Recommendation Report for Listed Building Consent for Alterations, Extension or Demolition of a
Listed Building

REF NO: P/163/21/L

LOCATION: Pennicotts Farm
Pagham Road
Pagham
PO20 1LN

PROPOSAL: Listed Building consent for the demolition of existing conservatory to southern side of building & general repair & maintenance of external brickwork & roof coverings, insertion of 2 No conservation style rooflights to the rear valley roof, & formation of 2 No sets of double patio doors within existing window openings on the northern elevation. Internal alterations comprising the removal of partition walls, reinstatement of wooden balustrade to staircase, and general repair, maintenance and refurbishment.

Ve.	In.	Project	Title	House A
A	FR	Pennicotts Farm	FF Staircase	
B	FR	PO20 1LN		
C	FR

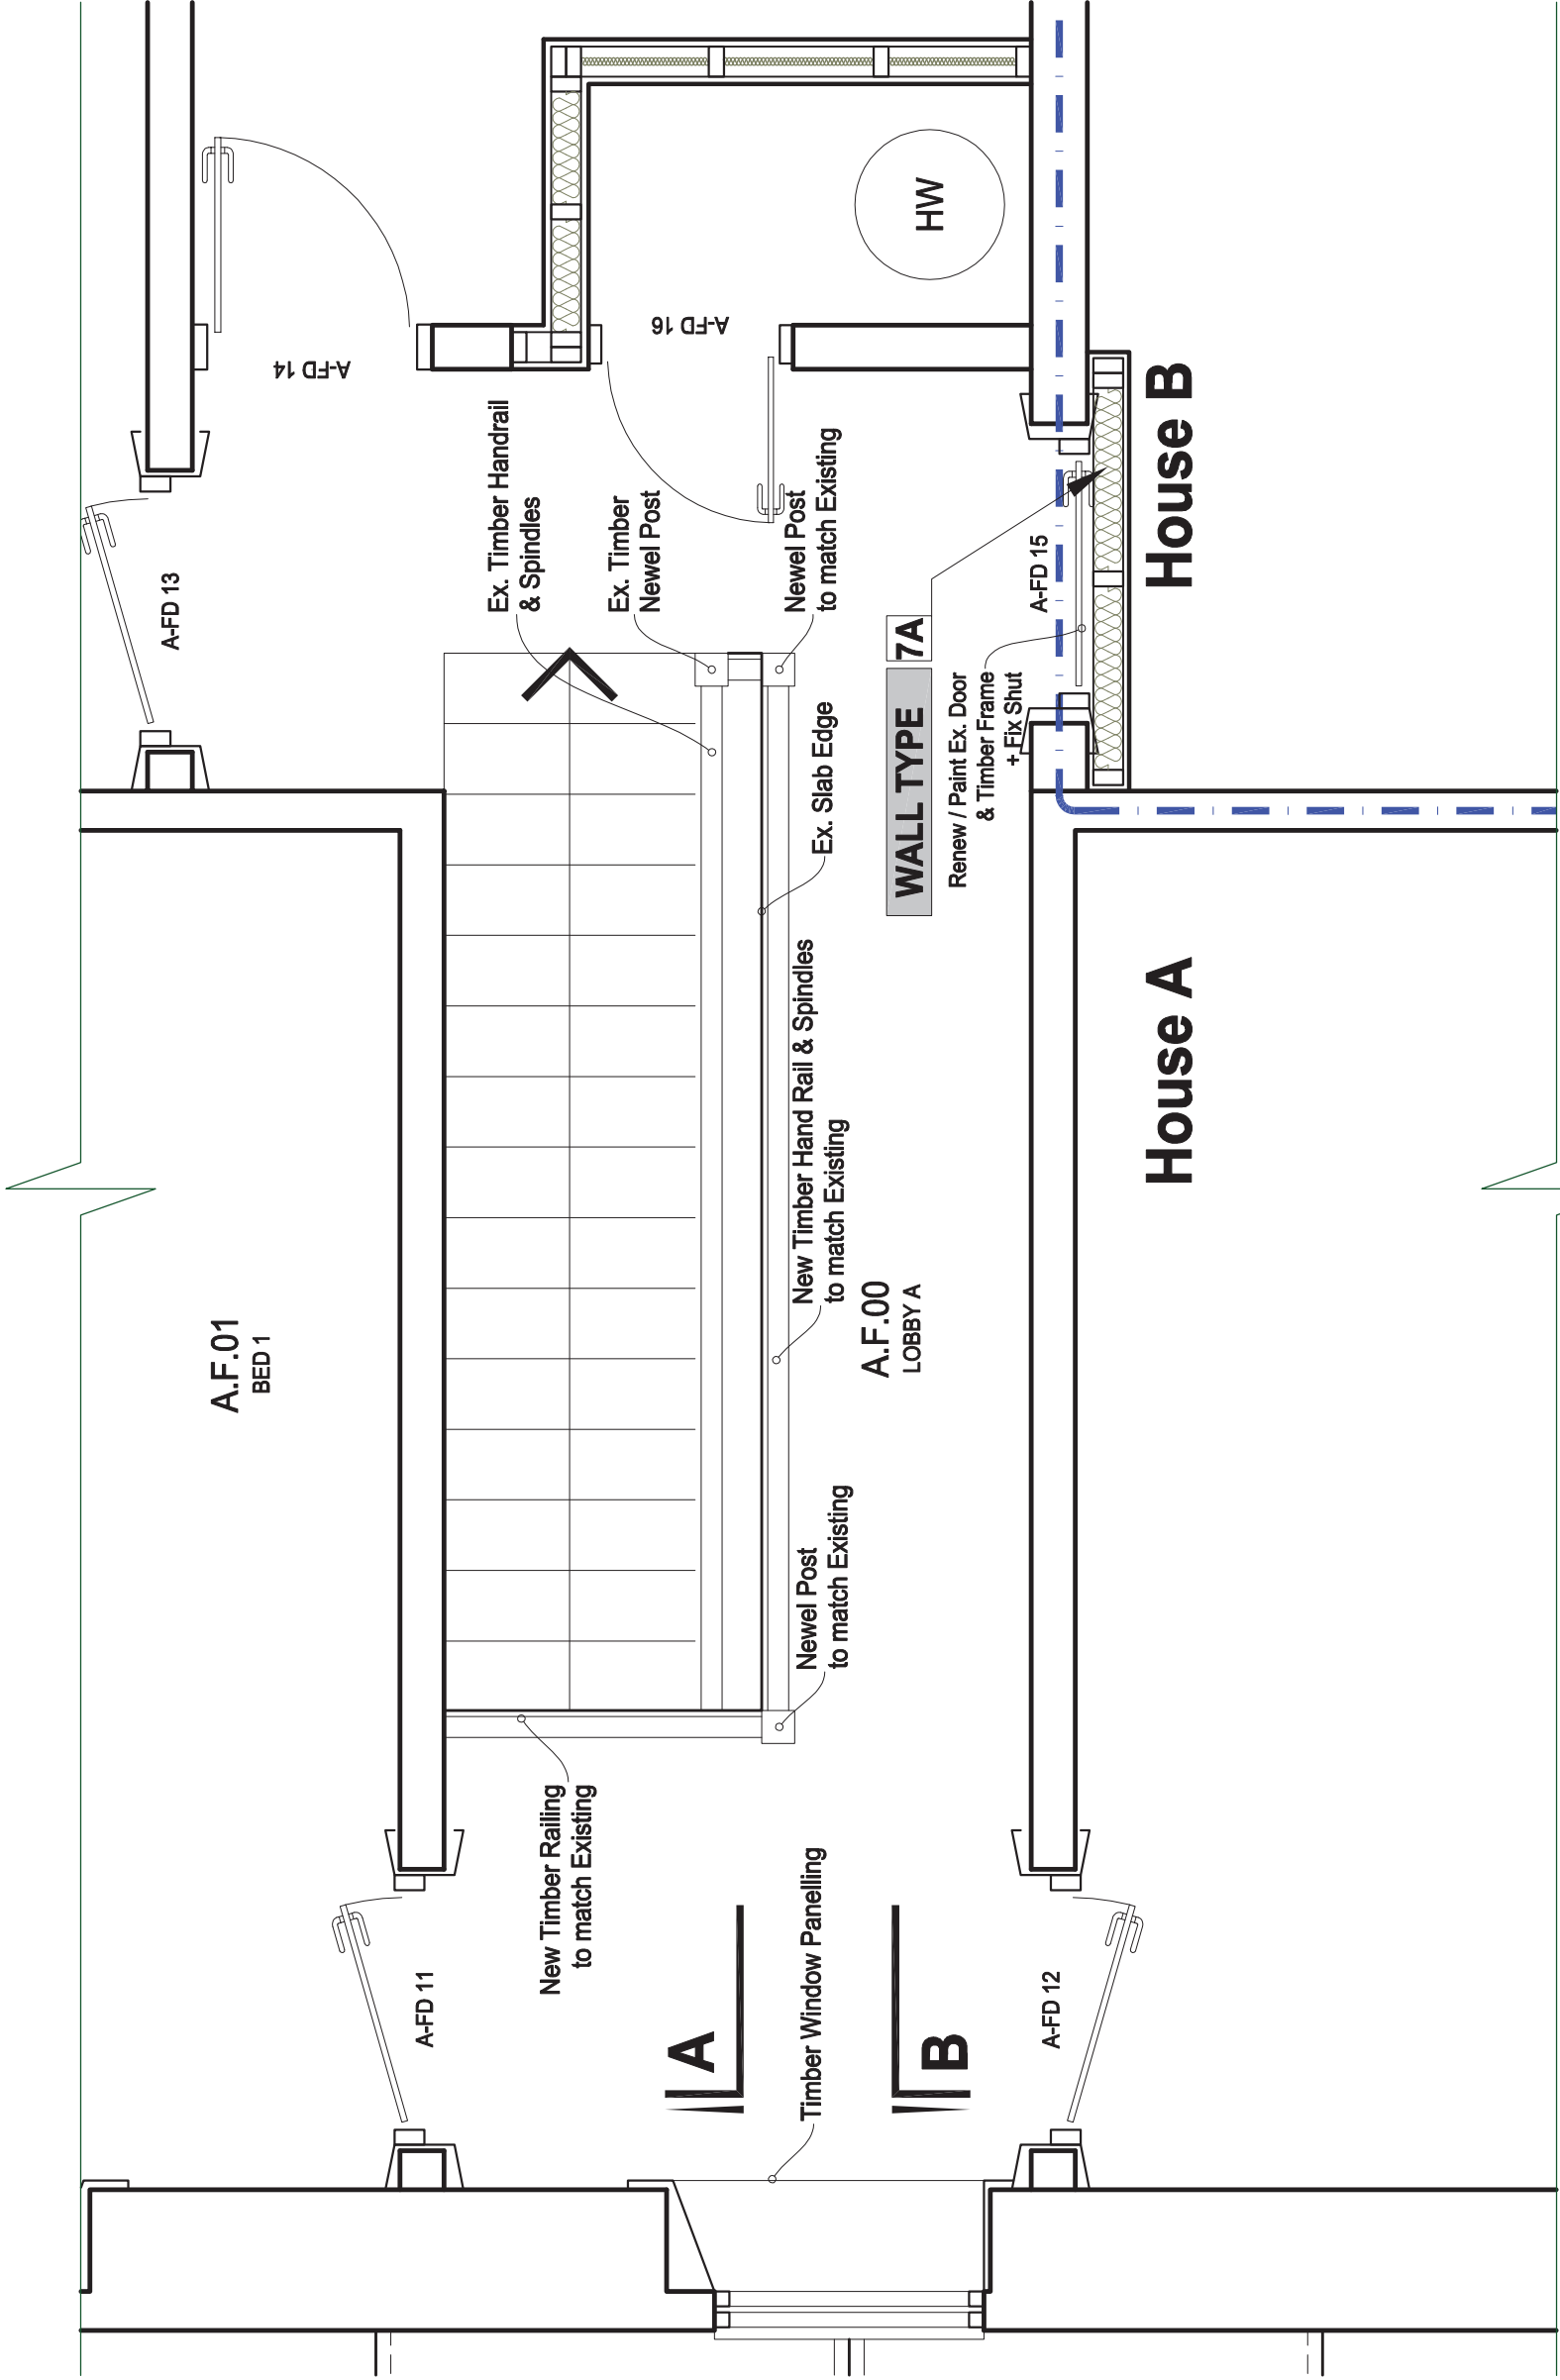
On the floor plan (FF Plan Structure) and 'House B FF Staircase' it looks as though door A-FD15 is removed (reference is made to 'block up opening'), where as in both the plans showing the 'section for house A staircase' (House A section staircase B-B section) and 'House A FF Staircase', the door is to be fixed shut, however again unclear which one is relevant and only the latter is the acceptable approach. There is another door which will be blocked up and the door recycled, without justification on the first floor of landing B. It is not clear from the various plans what would happen to the 're-cycled' doors.
